REQUEST

Current Zoning: B-D(CD) (Distributive Business, Conditional), IC-1 (Institutional Campus), OFC (Office Flex Campus)
Proposed Zoning: N2-A(CD) (Neighborhood 2-A, Conditional)

Approximately 14.9 acres located west of Nations Ford Road, east of Hebron Street, and south of Arrowood Road.

The petition proposes to develop a vacant, wooded property in the Nations Ford Road corridor with a community of 130 multi-family attached dwelling units.

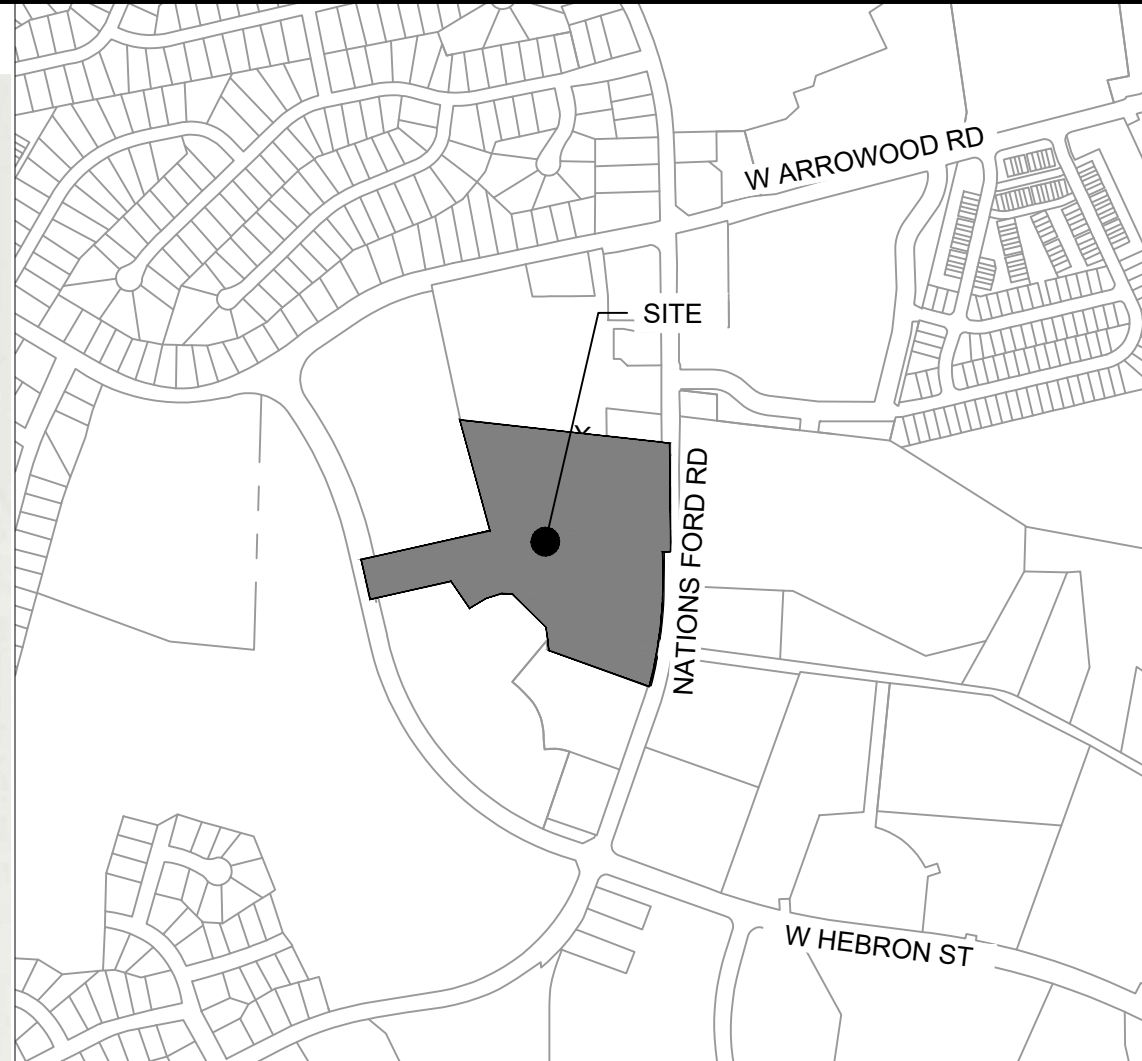
1. Update the site plan road dimensions for Old Hebron Road, Road A, Road D, Road C to dimension based on standard 2.5ft curb and gutter instead of valley gutter, revise callout on site plan to reference 2.5-foot curb and gutter and not valley gutter. Please add the CLDSM detail on the site plan within the road labels for each (which will give flexibility per CLDSM to construct the appropriate section during permitting). Road B and C can remain without specific CLDSM label.
